CITY OF ALBUQUERQUE

January 29, 2018

**RE: Marble Townhomes
Grading Plan and Drainage Report
Engineer's Stamp Date: 01/24/18
Hydrology File: J18D046**

RE: Marble Townhomes
Grading Plan and Drainage Report
Engineer's Stamp Date: 12/29/17
Hydrology File: J18D046

EROSION AND SEDIMENT CONTROL PLAN

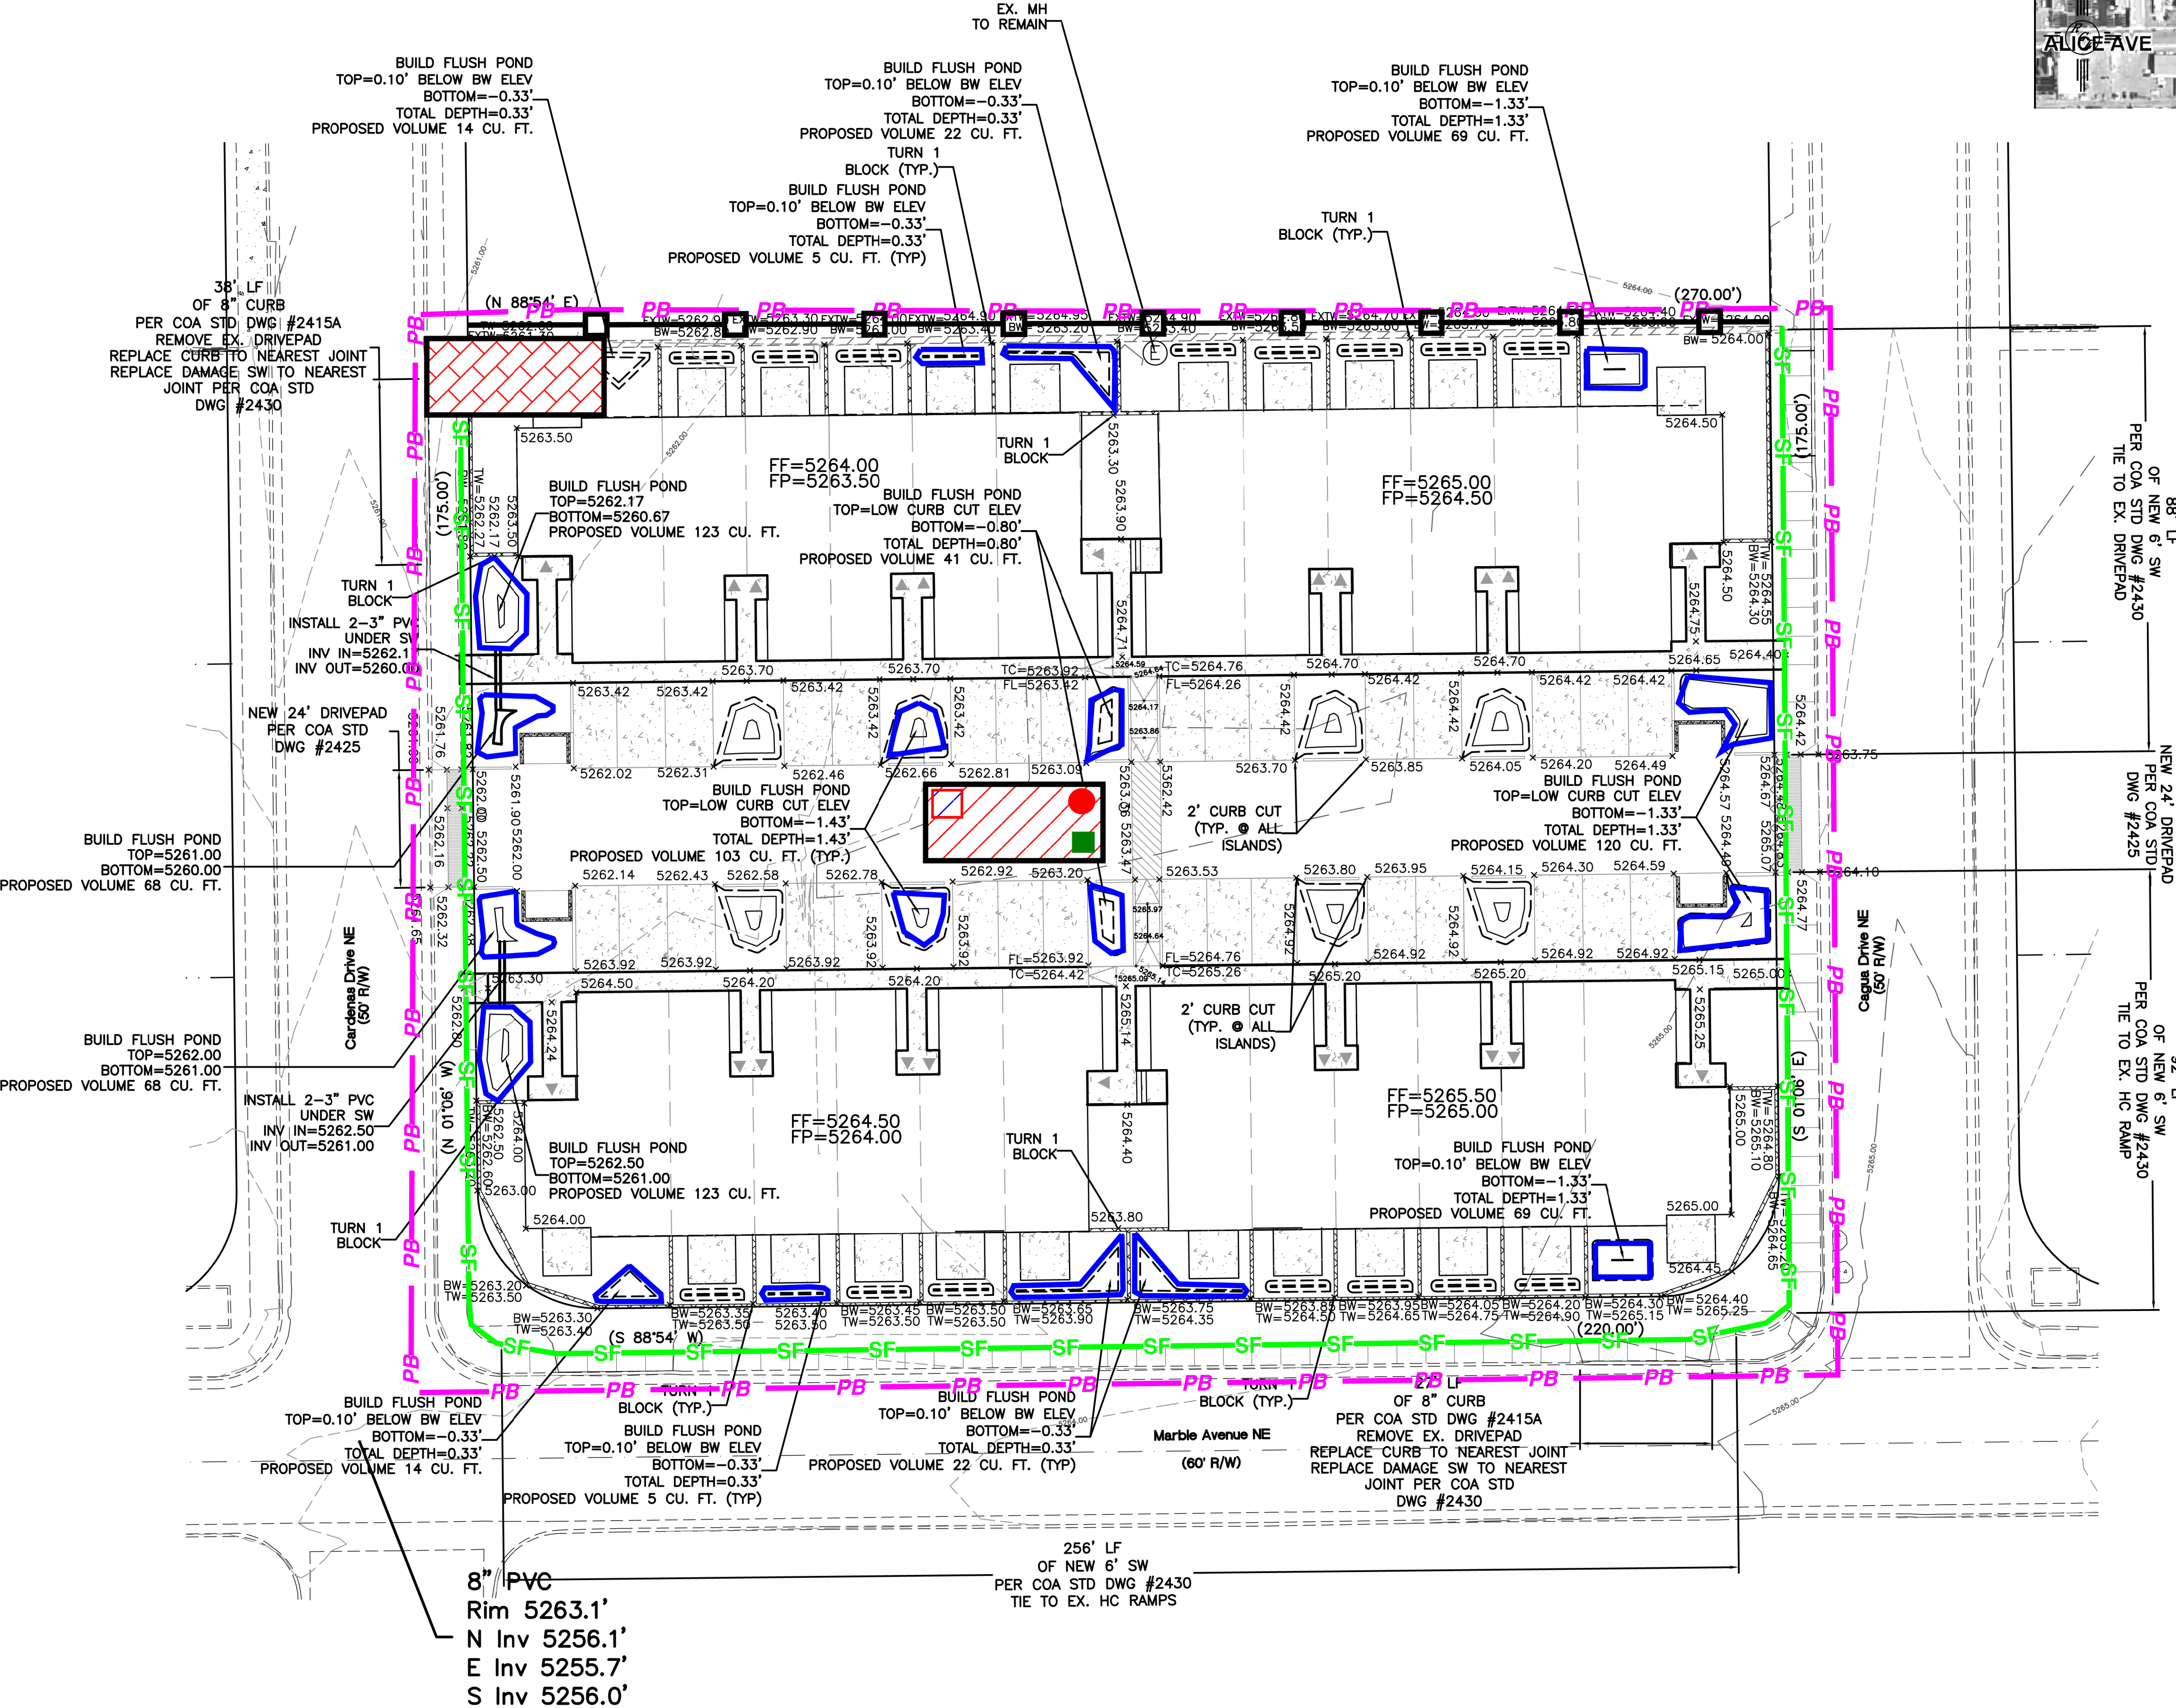
1. The site currently shows more than 1 acre of disturbance is being proposed. An Erosion and Sediment Control Plan is required and has to be submitted to the storm water quality engineer (Curtis Cherne, PE, ccherne@cabq.gov). Hydrology's approval for Grading or Building Permit will not be given until the submittal of the ESC Plans. **ESC was prepared and submitted**
2. Please provide a note showing the first flush required volume and the first flush provided volume. **We have shown this in the calculation table**
3. Please provide a typical detail for the turned CMU block. This block needs to be at least four (4) inches above the proposed grade to avoid clogging.
we have added detail
4. There are two missing remove drivepad & replace with curb & gutter note as outlined in the following photo.
we have incorporated the additional existing drivepads

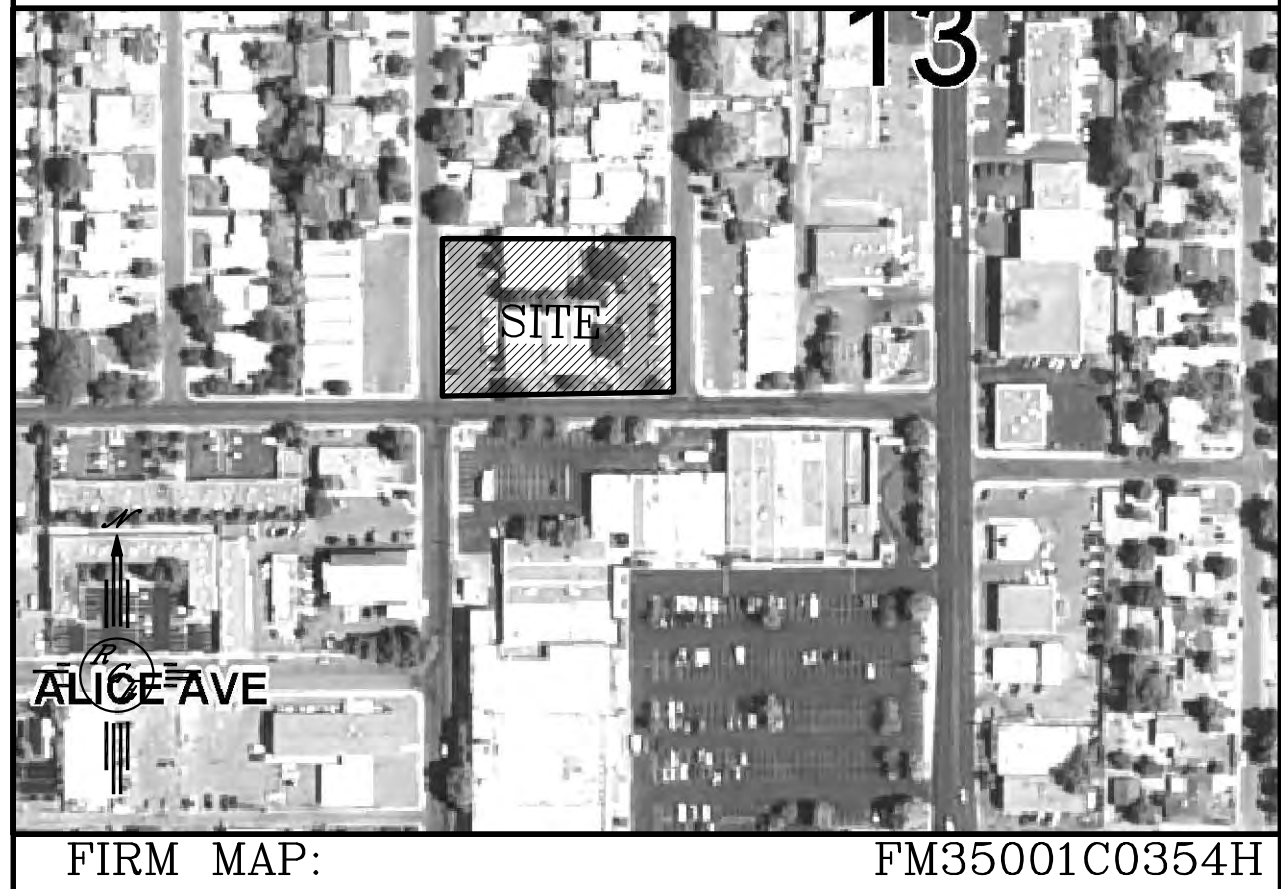
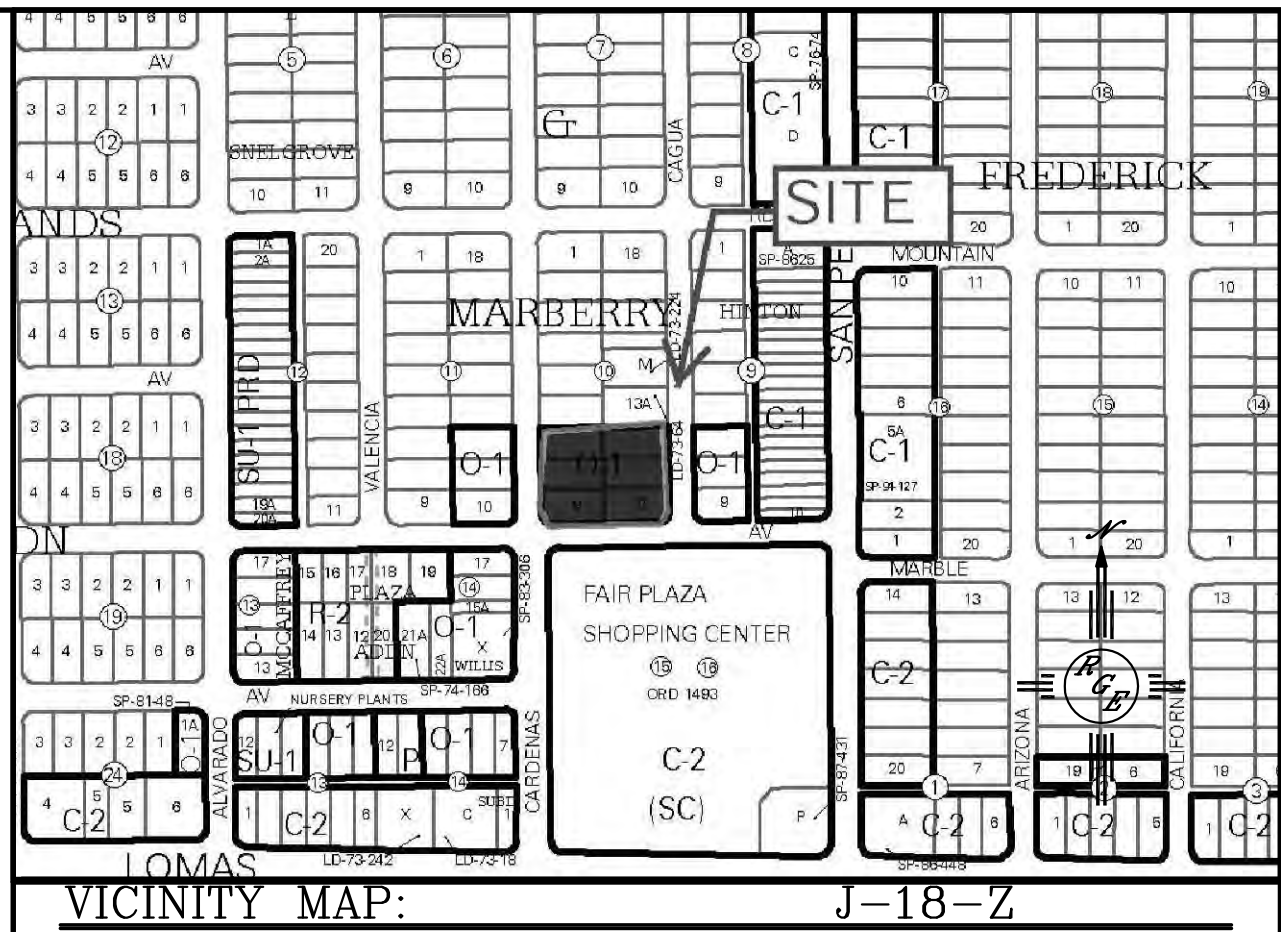
1. Under the Existing Conditions, it appears that about half of the site drains to Cardenas Drive and about half of the site drains to Cagua Drive with a small portion draining directly to Marble Ave. Please take another look at the existing conditions.

2. Provide a drainage map for the Existing Conditions and update the existing drainage calculations.

3. Under the Proposed Conditions, why not keep the drainage as per the appeared drainage conditions as outlined in #1 above?

We have modified the existing conditions map

We have added updated map and corrected existing drainage calculations

We have modified the plan to better match the correct existing conditions
